CITY OF ALBUQUERQUE

June 13, 2018

**Re: Janet Kahn School of Integrated Arts
Erosion and Sediment Control Plan
Engineer's Stamp Date 6-4-18 (H20E028)**

ESC-1

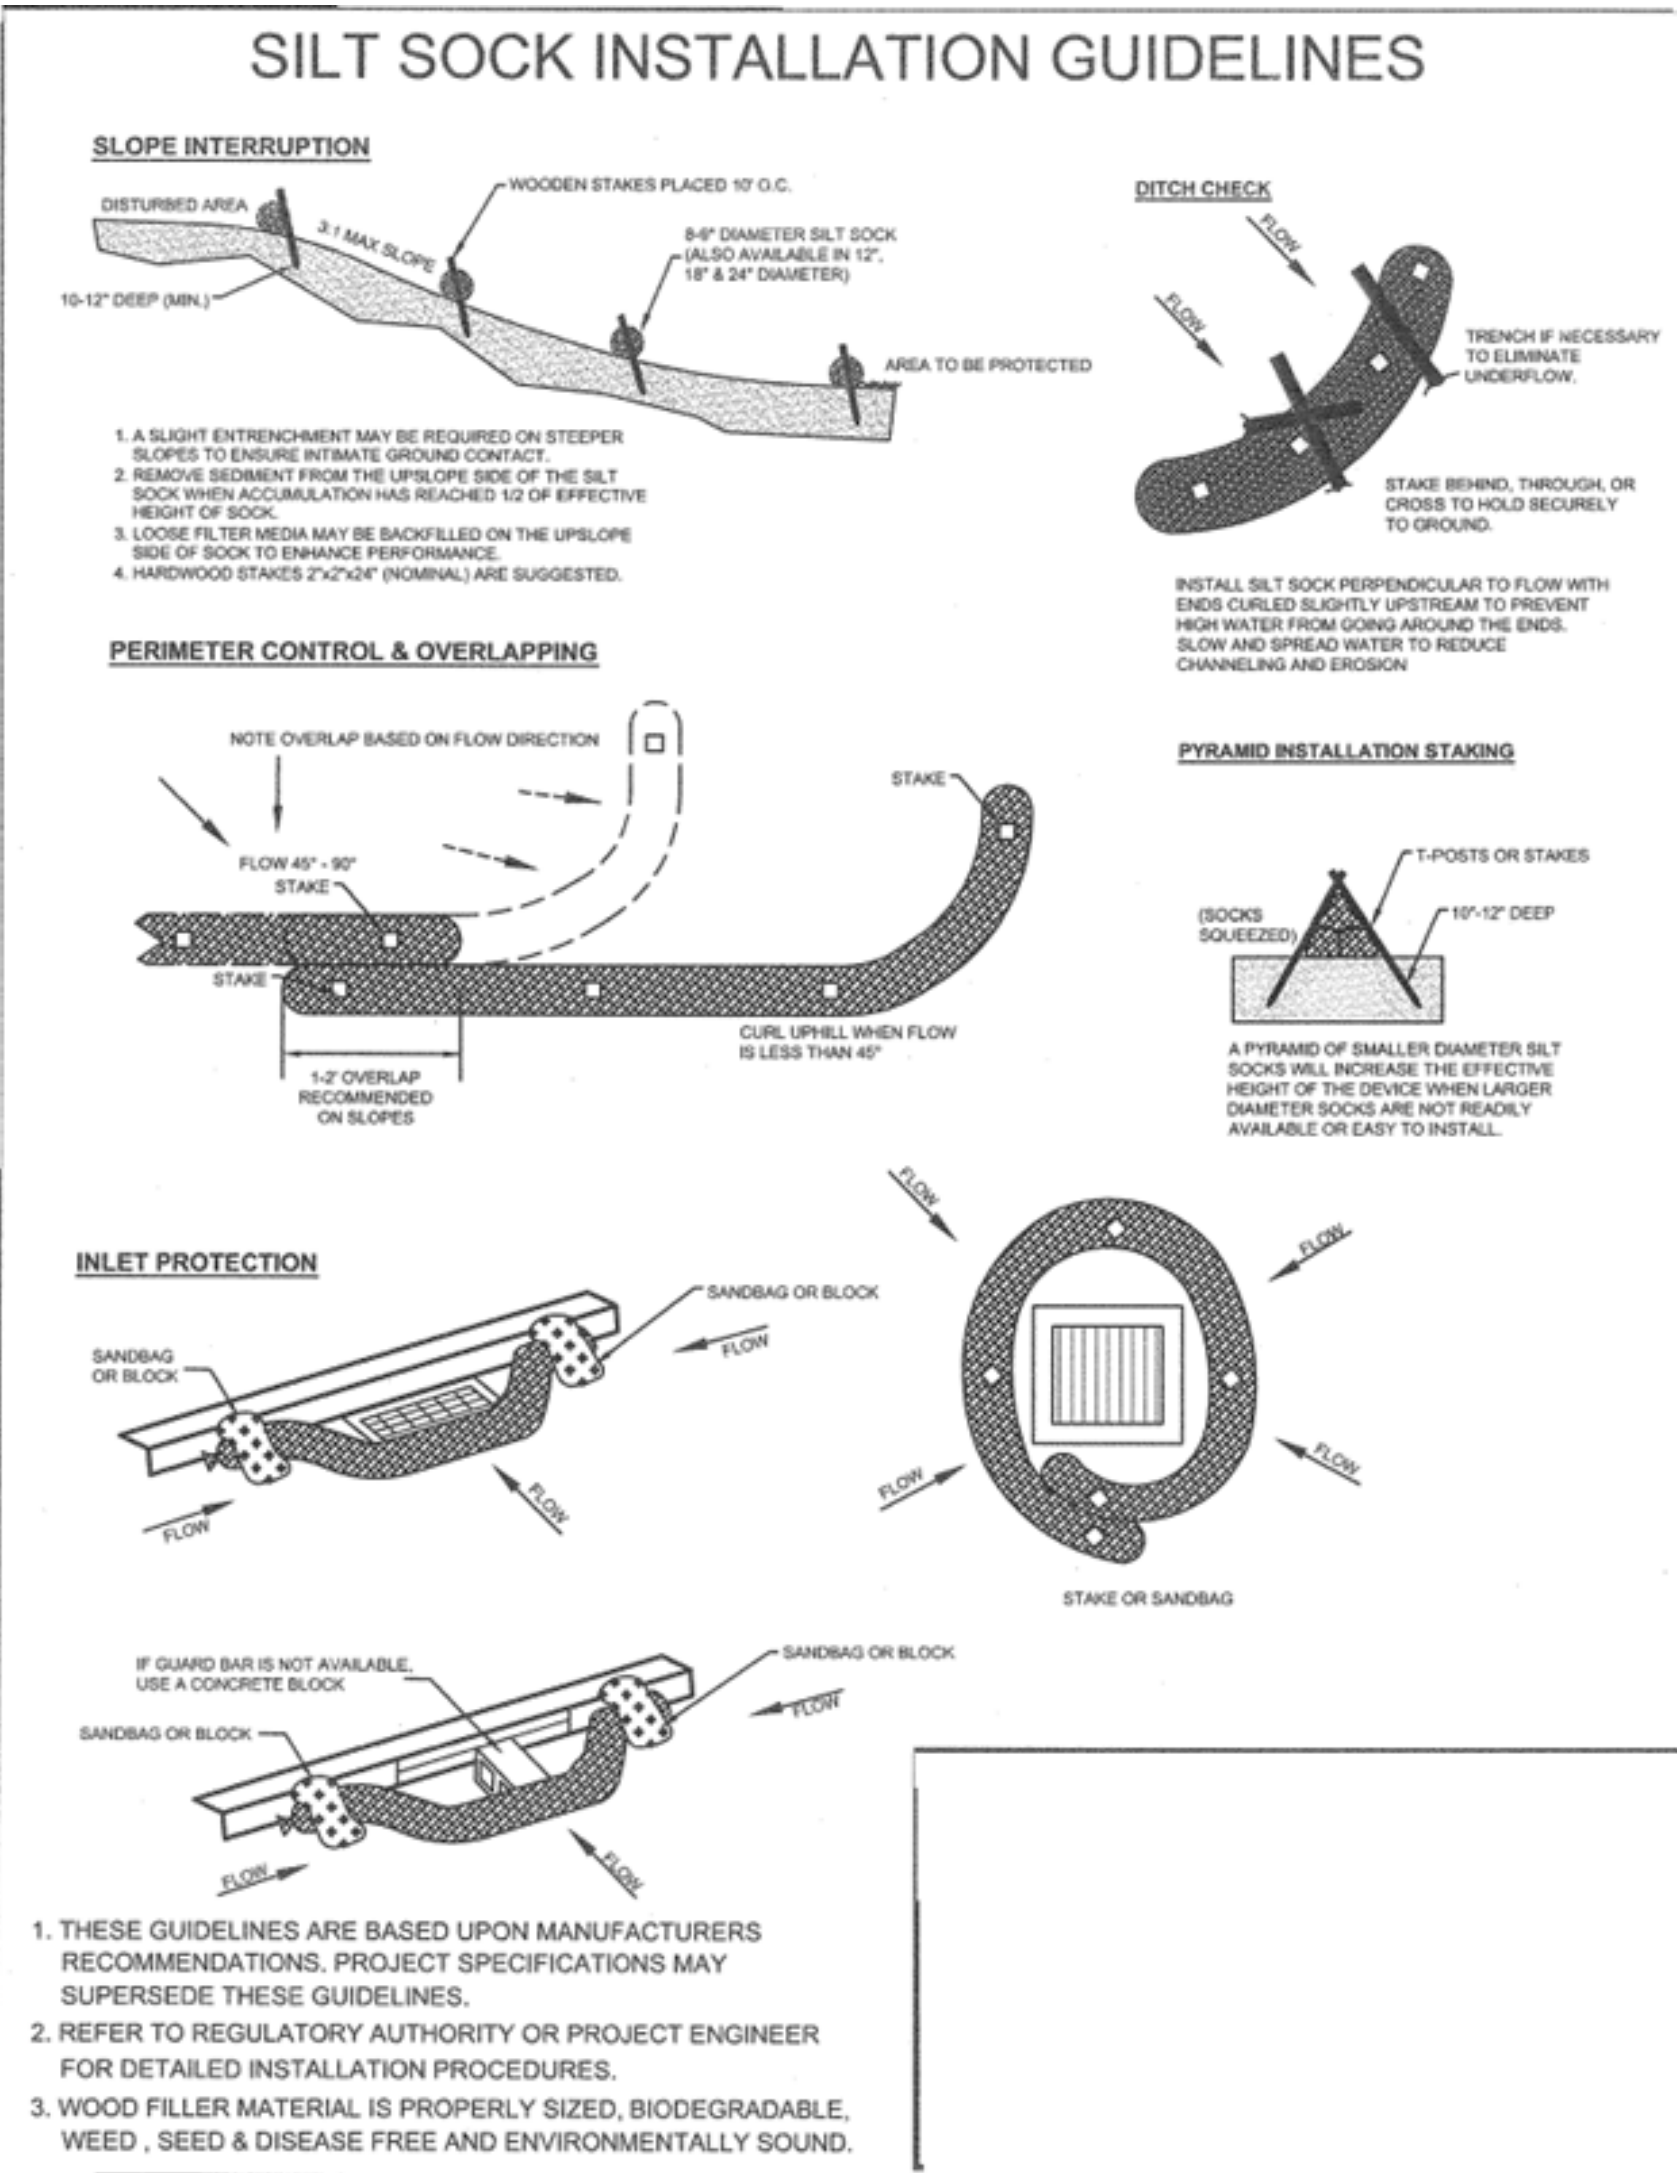
1. Grades are not provided.
2. There is no vicinity map.
3. A silt fence alternate is shown on the plan, but there are no details for this BMP. A detail is required for each BMP shown.
4. A concrete channel borders the project on the northern edge. This should be shown and possibly a note added.
5. There is a detail for a "Stabilized Construction Entrance", but a "Knock-Off Rock" BMP is shown on the plan. There is no detail for the "Knock-Off Rock" and "Stabilized Construction Entrance" is the preferred terminology.
